Development Facilitation Team (DFT) – Review Comments

Project No: PR-2020-003259 Date: 02/26/2025 Agenda Item: #2 Zone Atlas Page: B-17, C-17

Request: Preliminary/Final Plat Application for Honeywell

Location: 9201 San Mateo Blvd NE

ENGINEER'S SEAL RONALD R. BOHANNAN P.E. #7868	HONEYWELL ALBUQUERQUE, NM	DRAWN BY JL
		DATE 9-10-2024
	SIDEWALK EXHIBIT- SAN MATEO BLVD	DRAWING
	TIERRA WEST, LLC 5571 MIDWAY PARK PL NE ALBUQUERQUE, NEW MEXICO 87109 (505) 858-3100 www.tierrawestllc.com	SHEET # 1
		JOB # 2023090

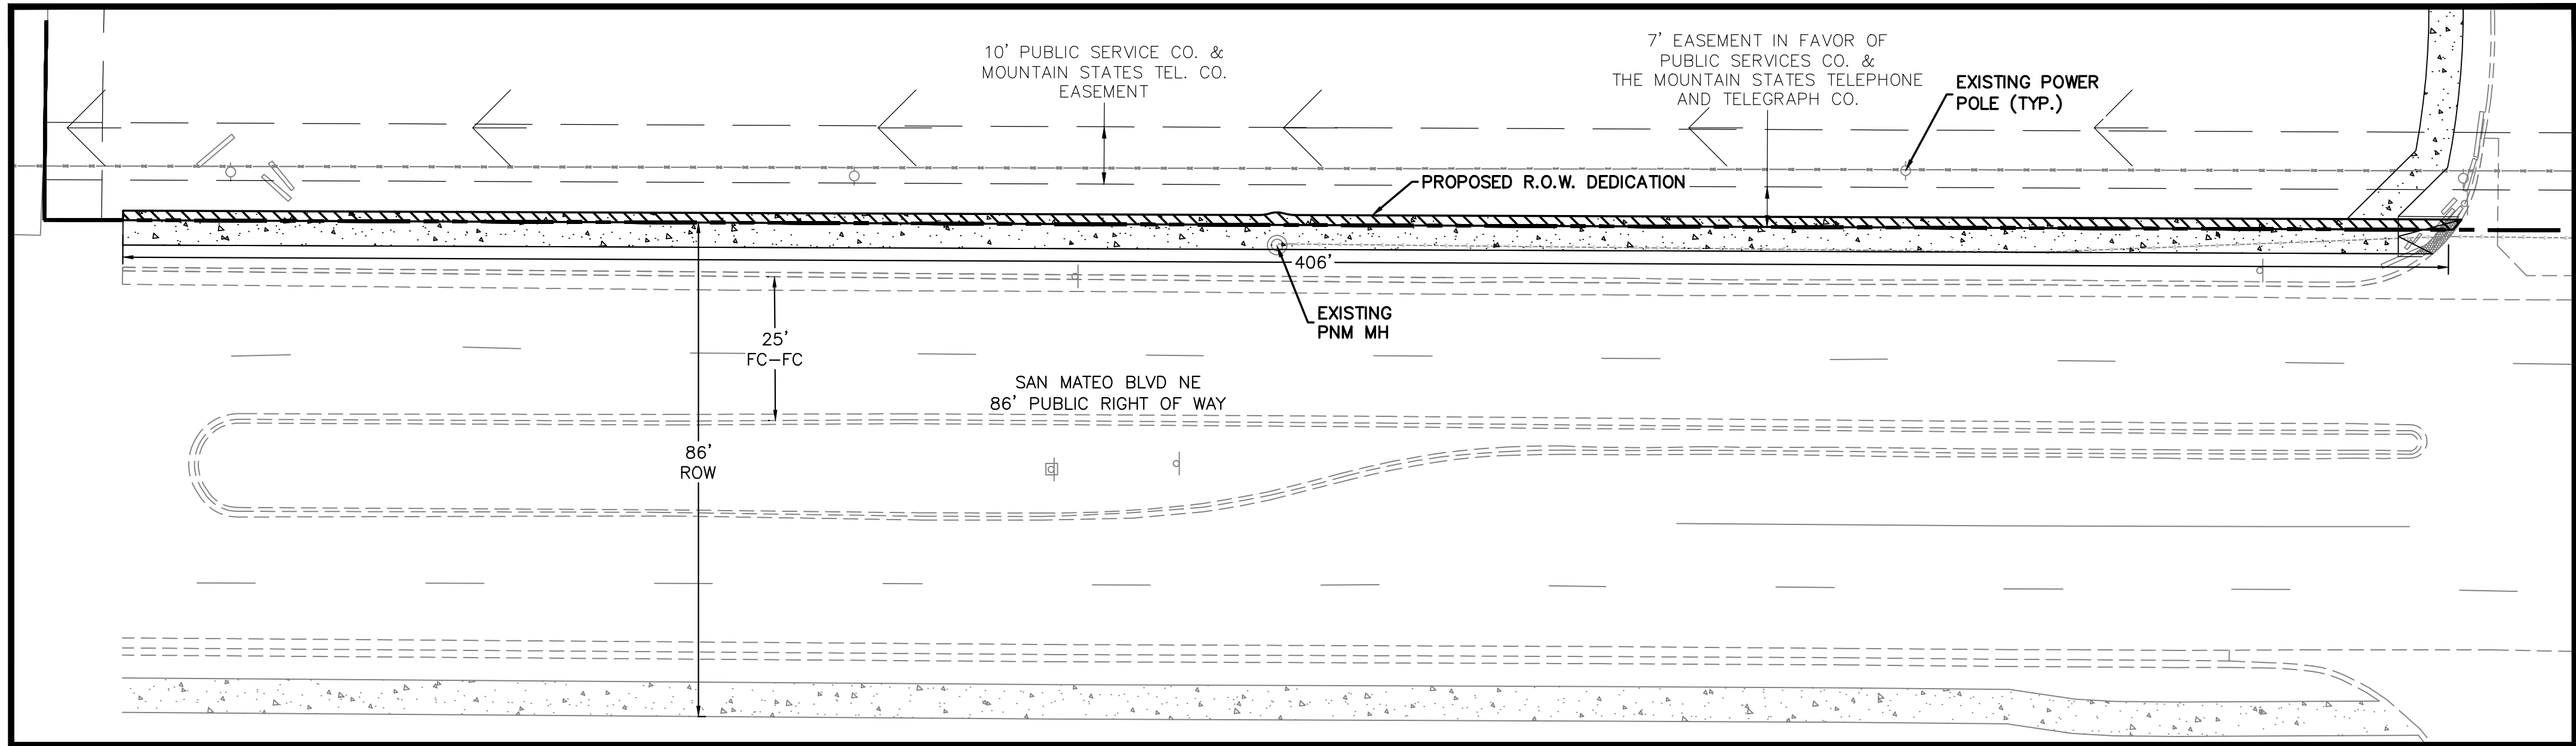
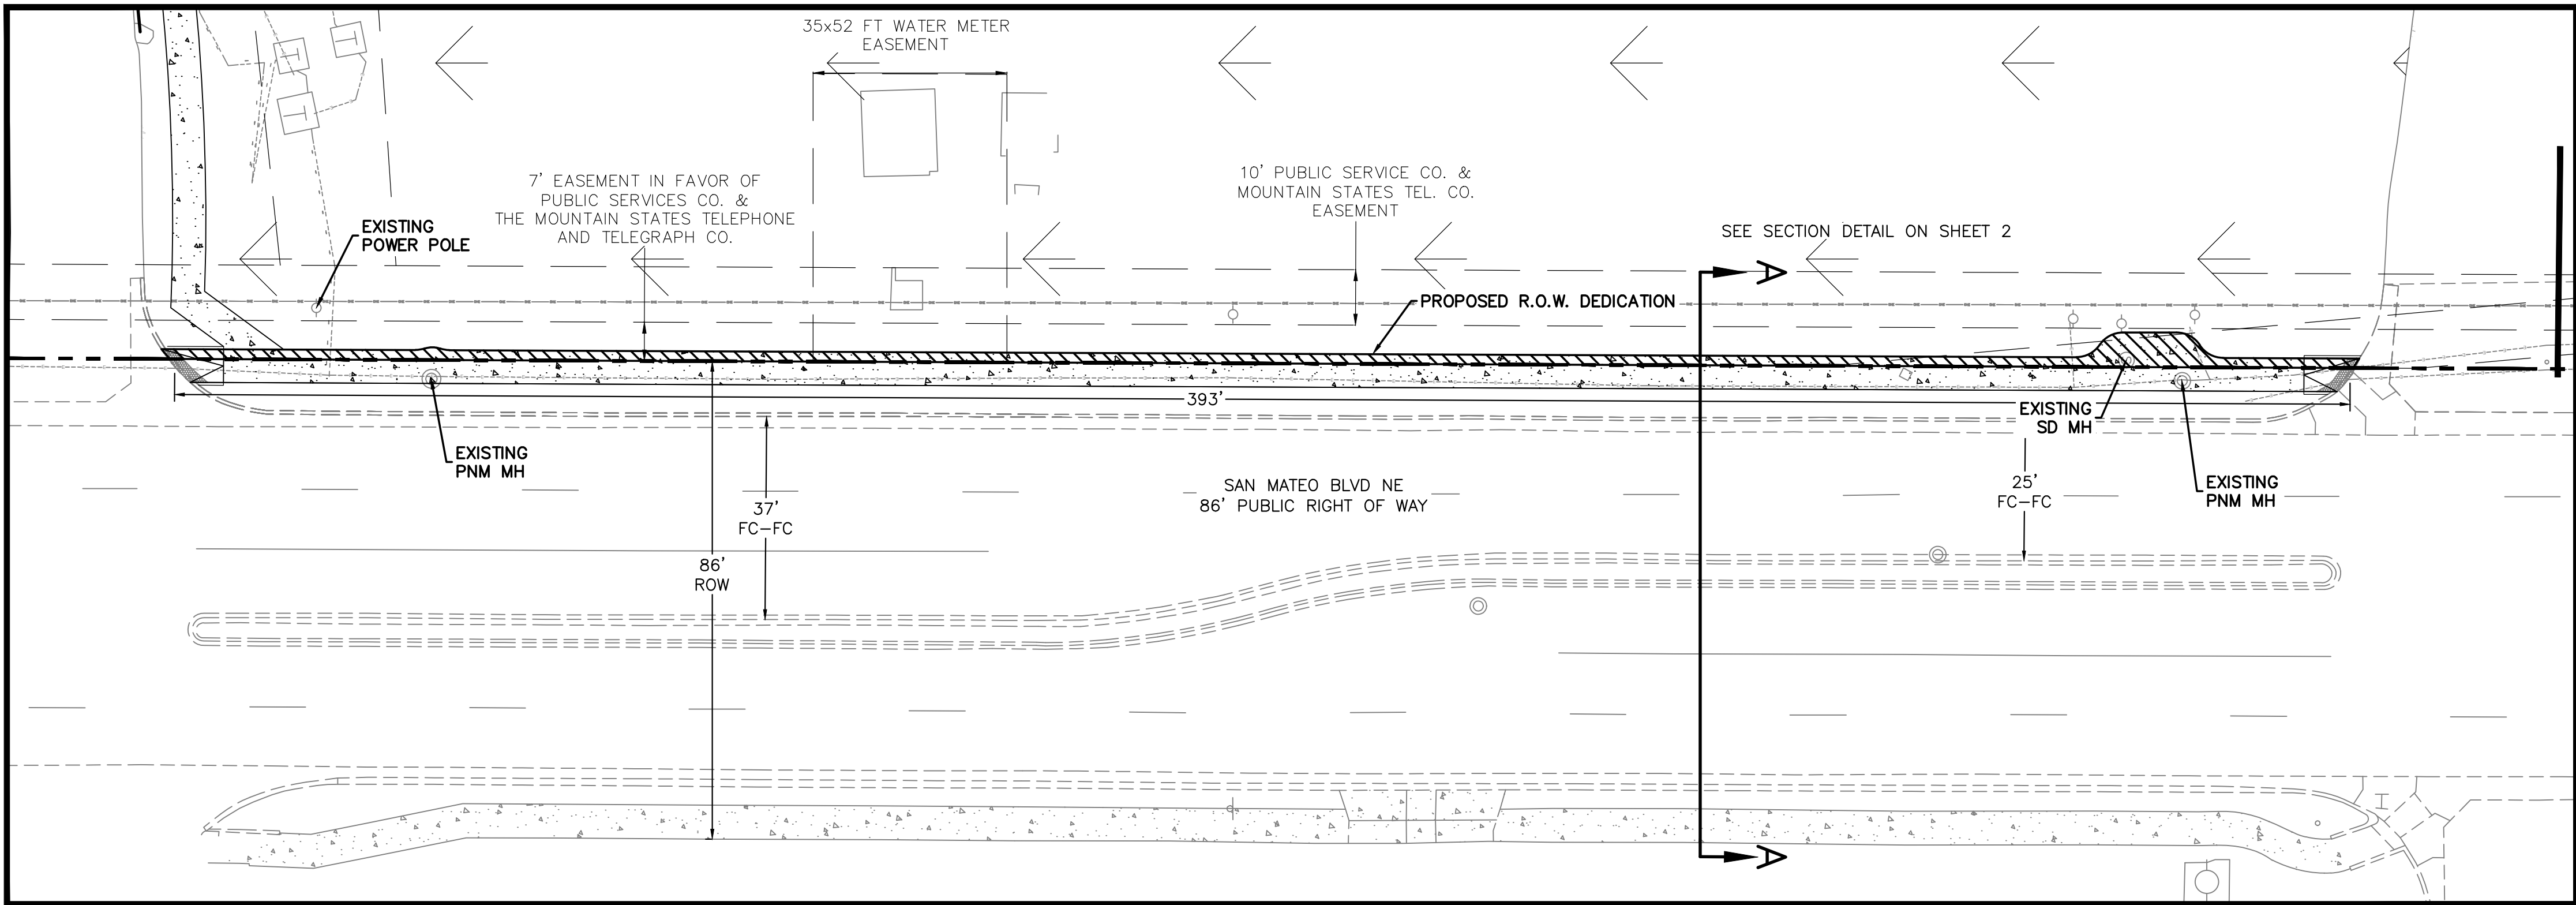
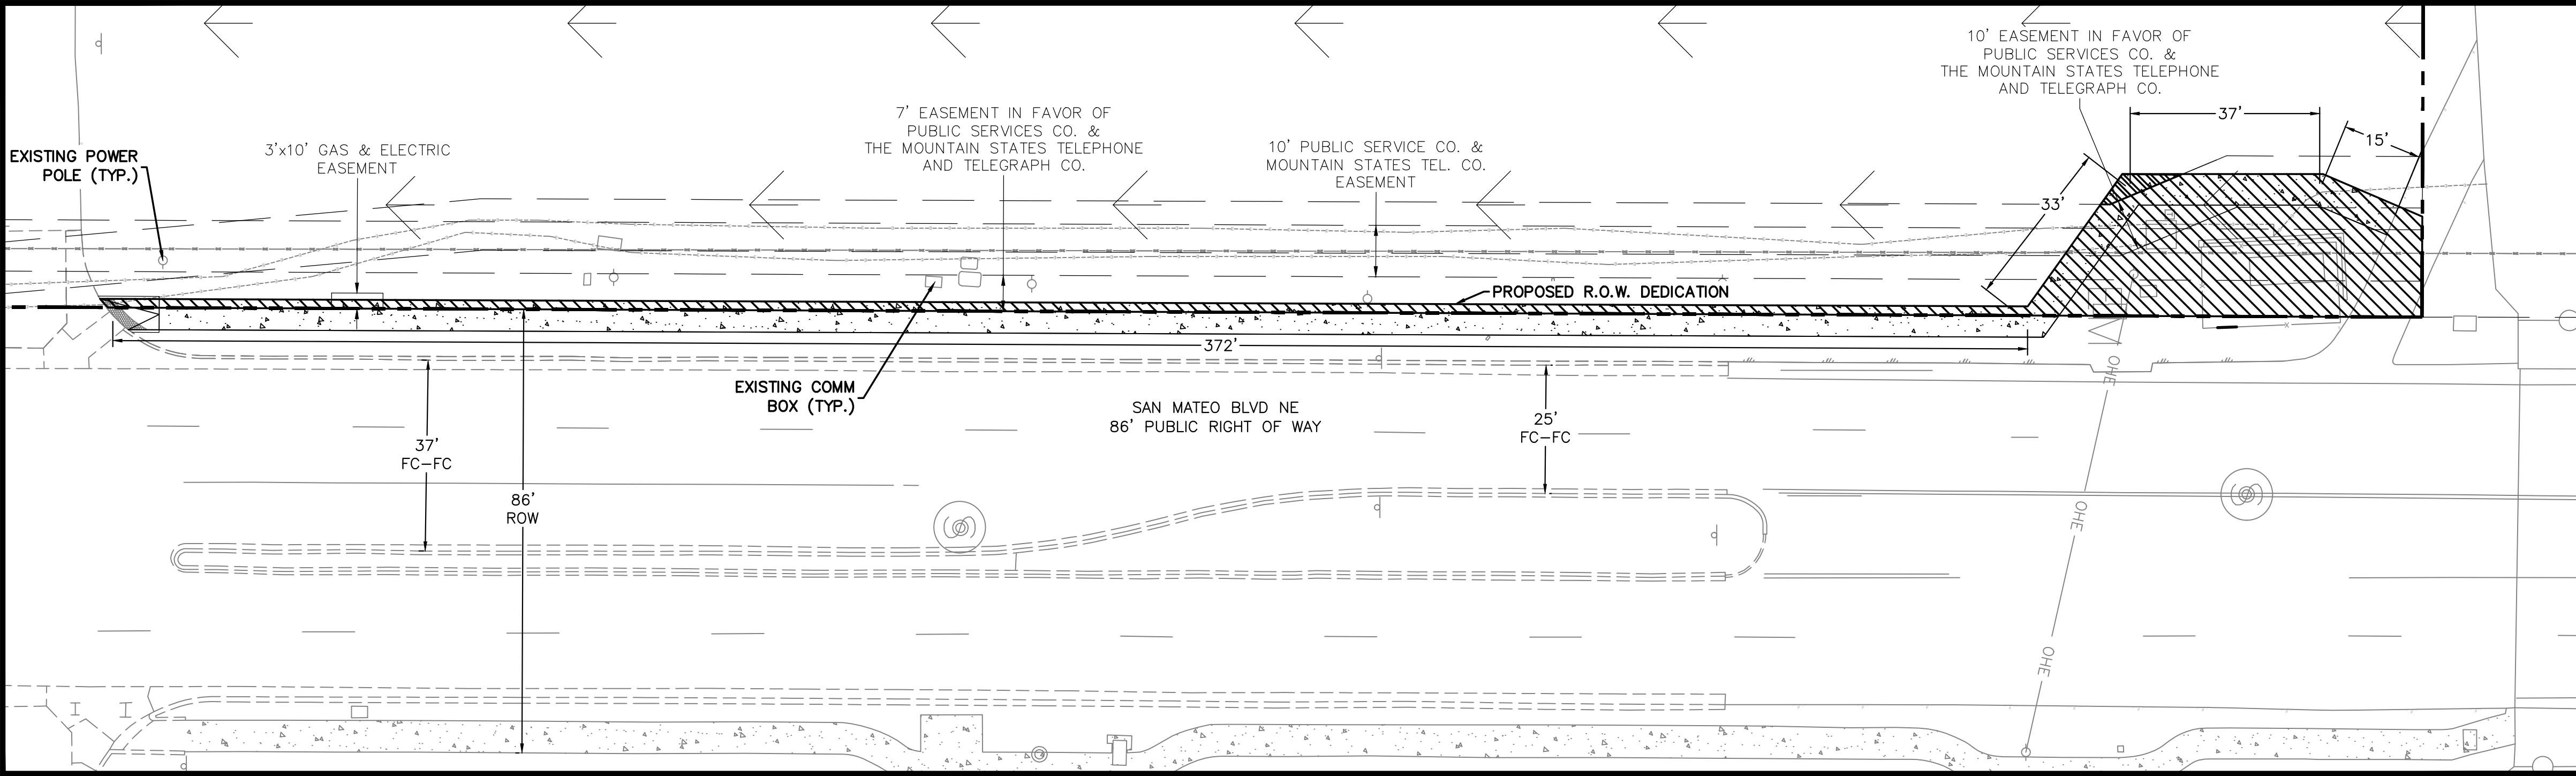
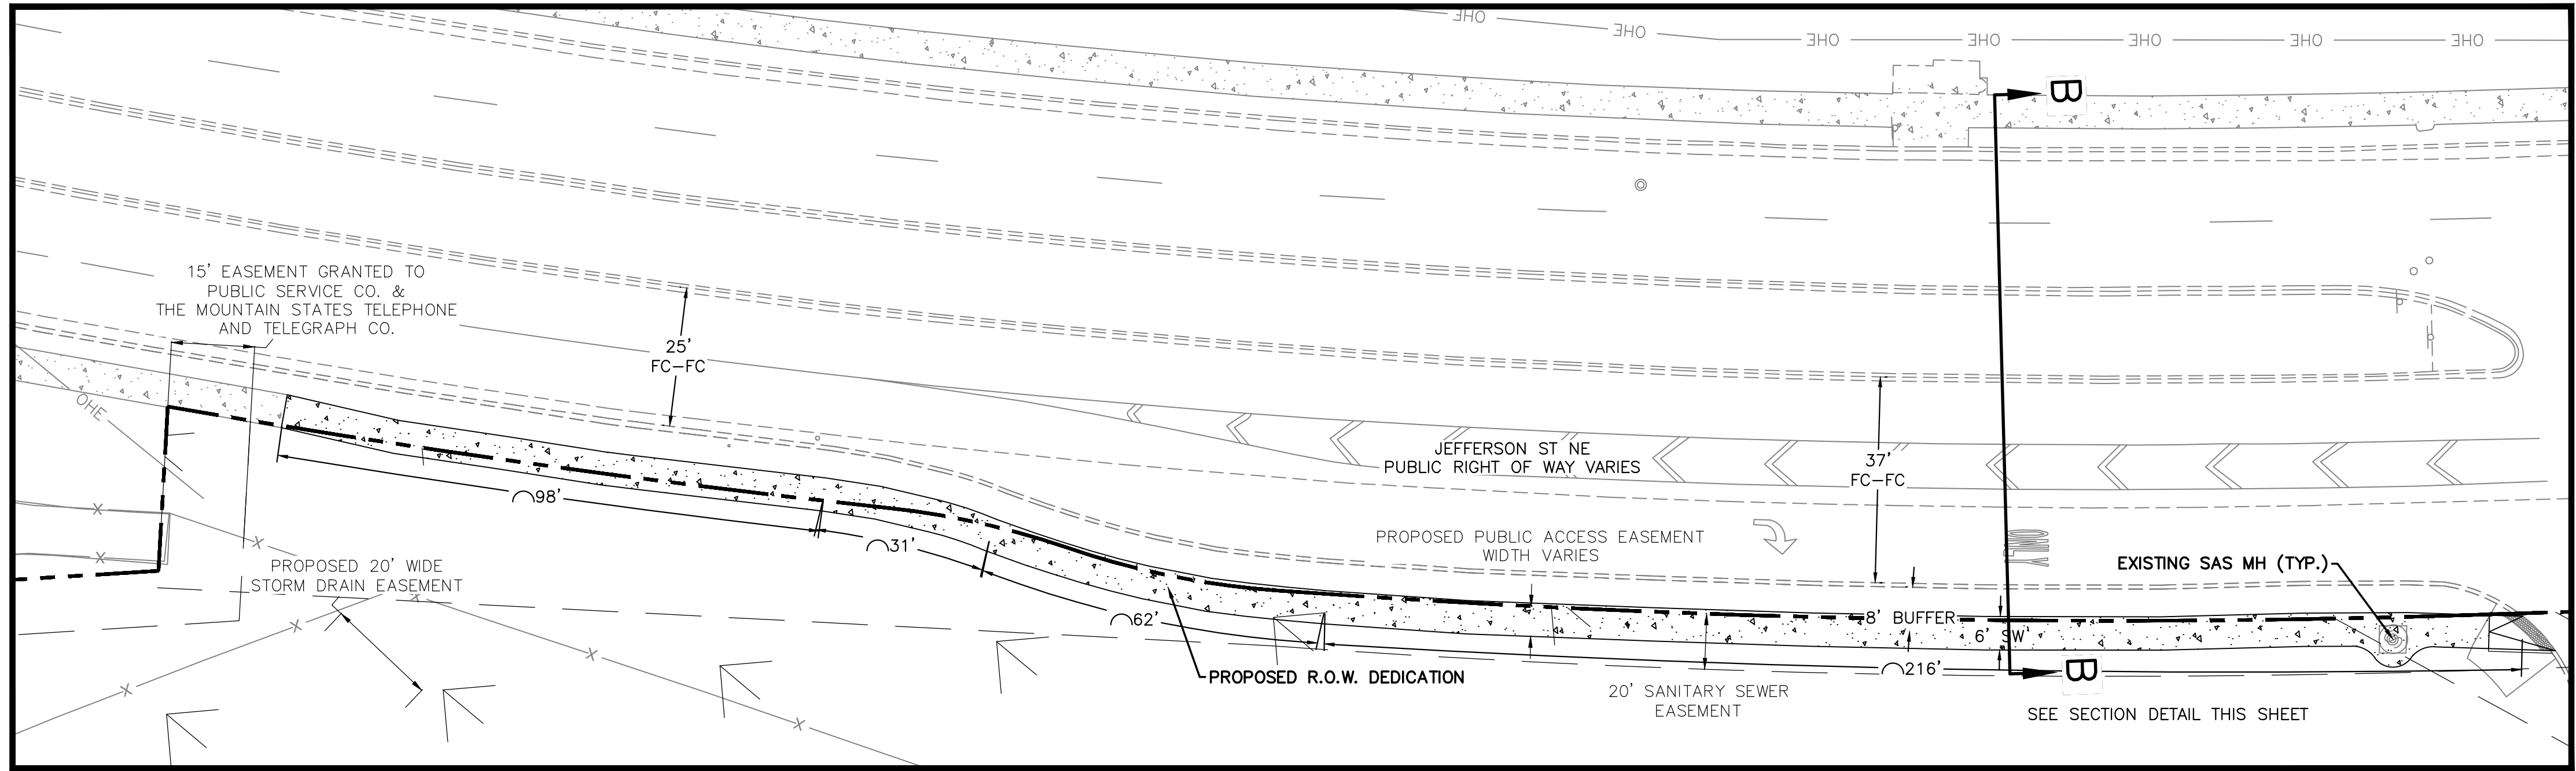
1. Transportation has an approved Conceptual TCL dated 6/25/2024.
2. Your plat has ROW dedication along San Mateo for proposed sidewalks, but is only proposing sidewalk easement for Jefferson. Is there a reason for this? The City prefers dedication over easements.
3. All work within the right-of-way and in public easement needs to be placed on an infrastructure list and financially guaranteed. This work will be done under City work order.
